Application No: FP/113/21/HH
Site Address: 14 Davenport Road Felpham PO22 7JR
Description of works: Hip to gable loft conversion with juliet balcony, alterations to fenestration/openings and external facade.

Thank you for your internet representation made on 24th June 2021 which has been recorded as an objection with the comments as follows:

Dwg No. 21009-P-107-D

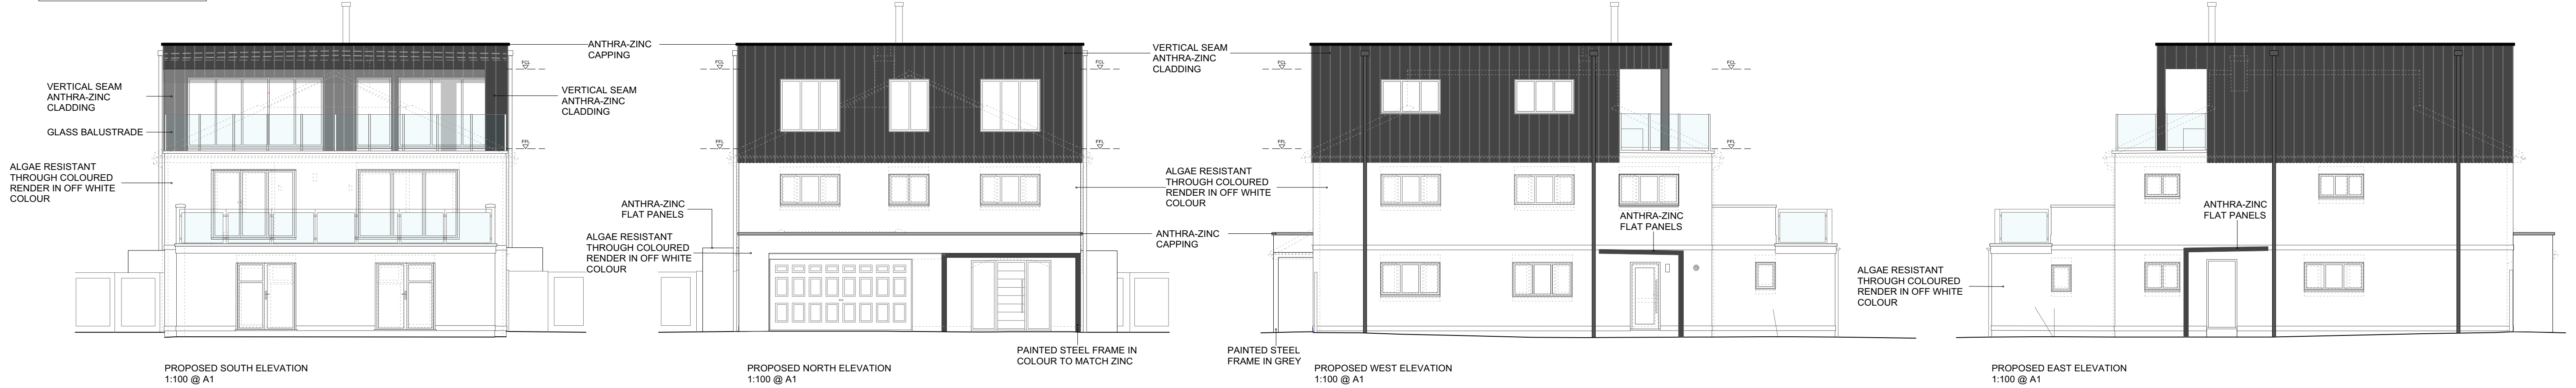
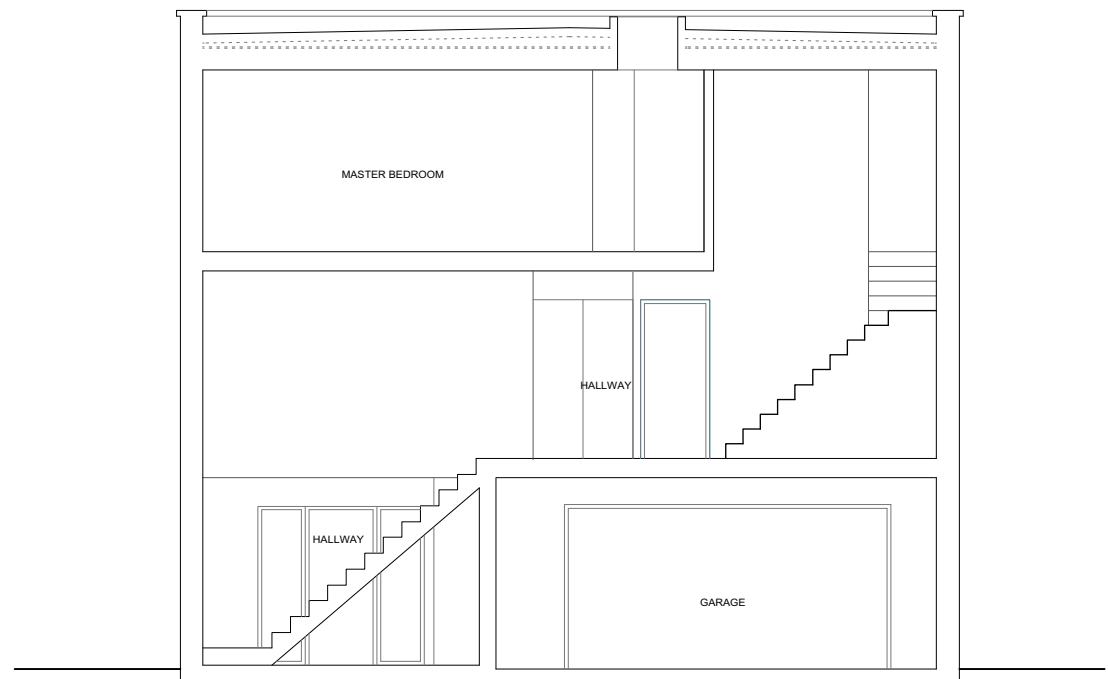
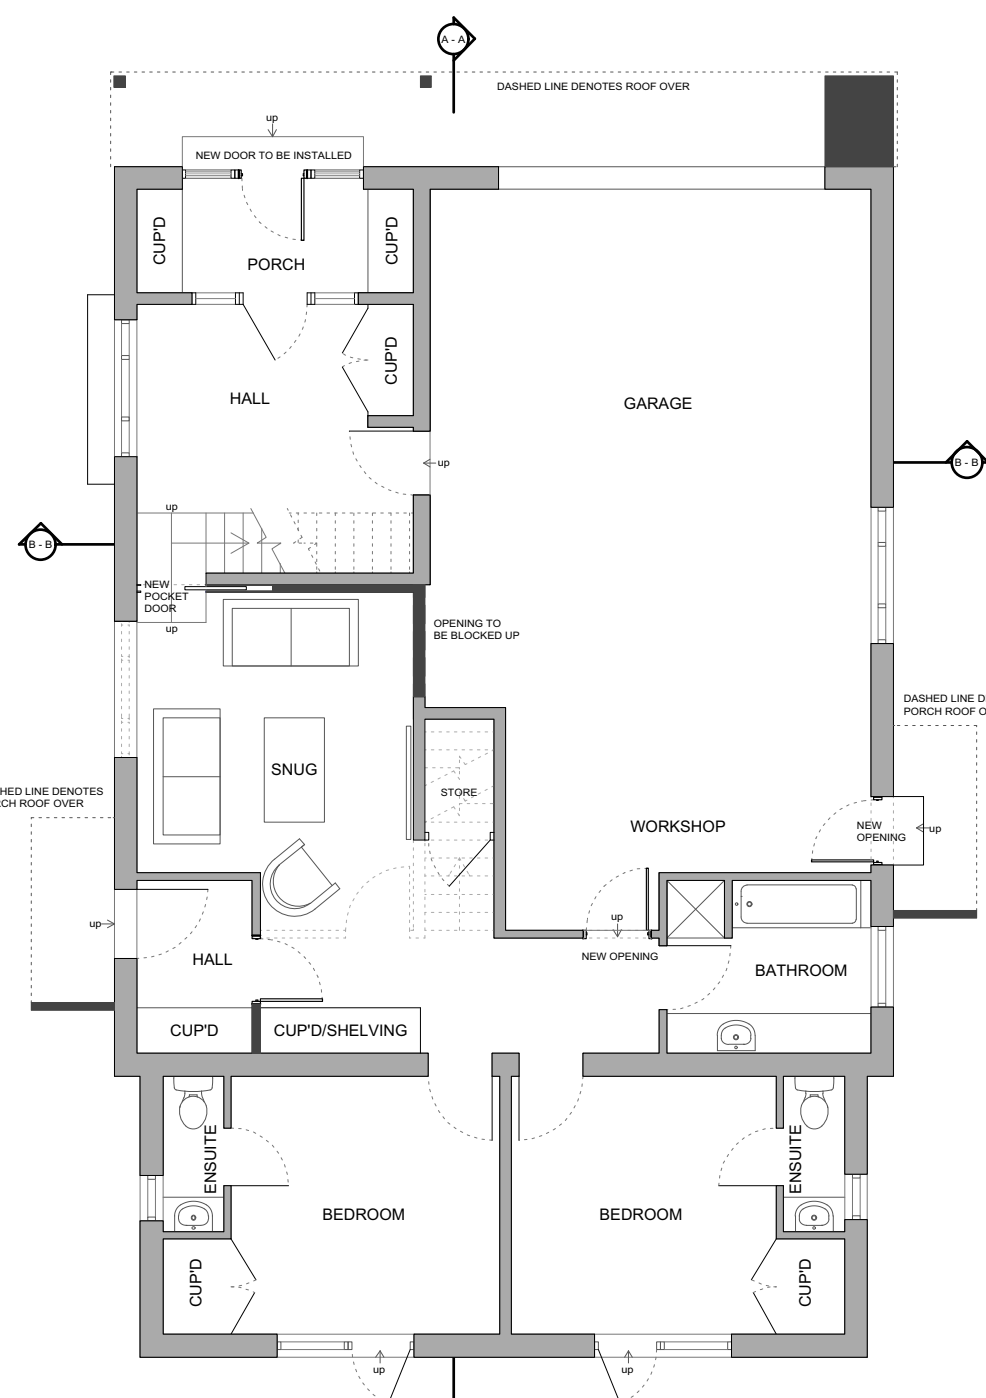
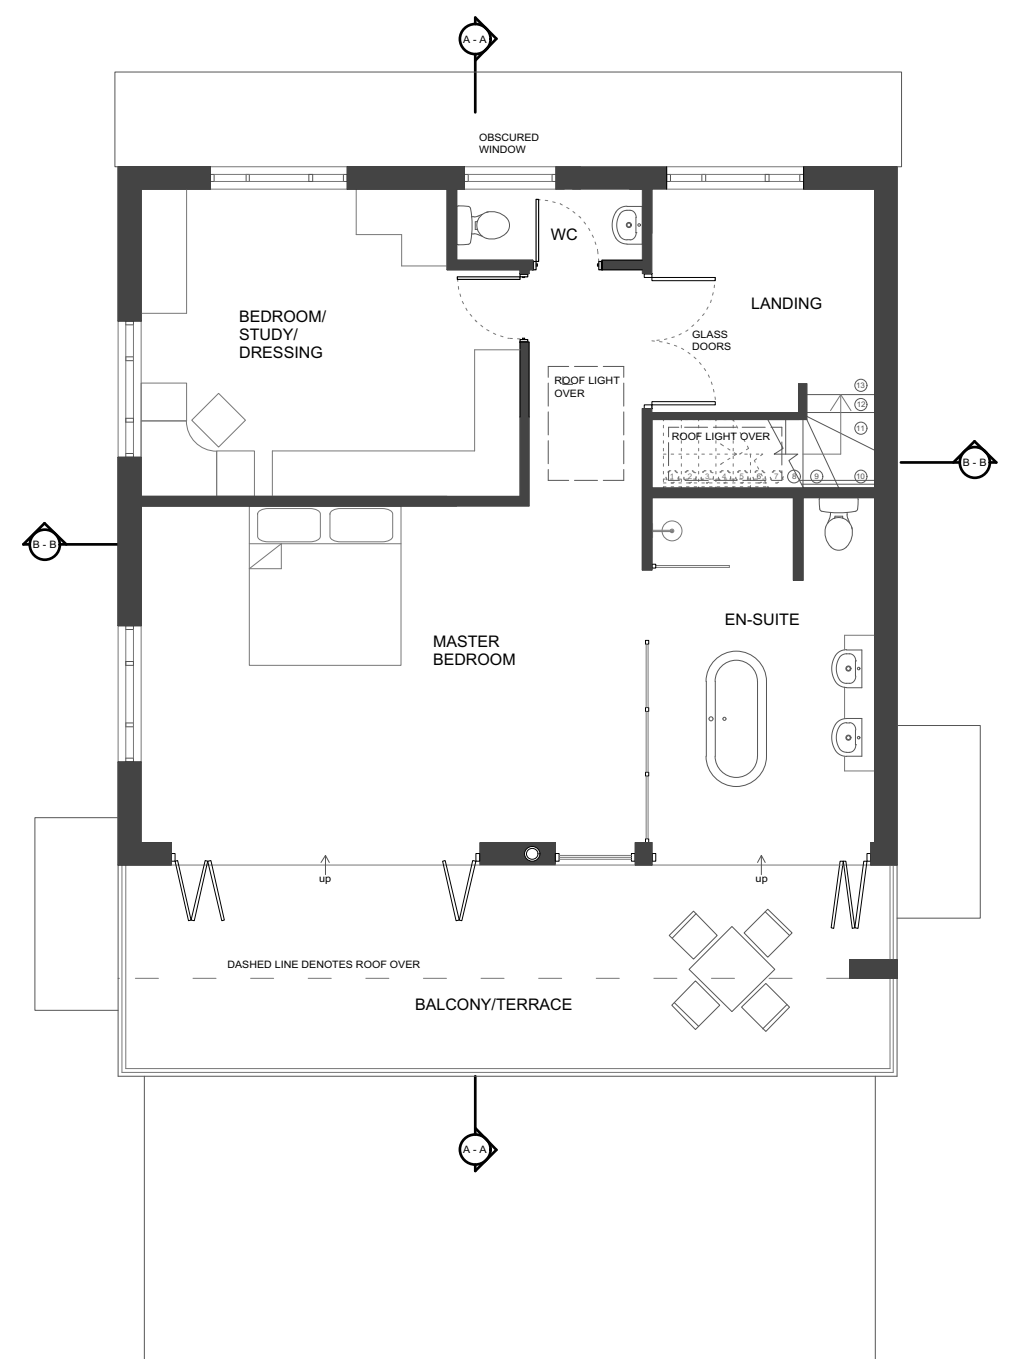
We live next door to this development, to the East. The extra floor does not have windows overlooking us but there is the balcony with glass allowing views to East, South and West. For privacy reasons we think the balcony should have a brick wall or glass that can't be seen through on the East and West. We also think 'Juliette Balcony' is a misnomer. Regarding the house style which others have commented on, we have no objection to that, but we do think the height should be reduced to be in line with the other house roofs (i.e. not inline with the existing chimney pot).
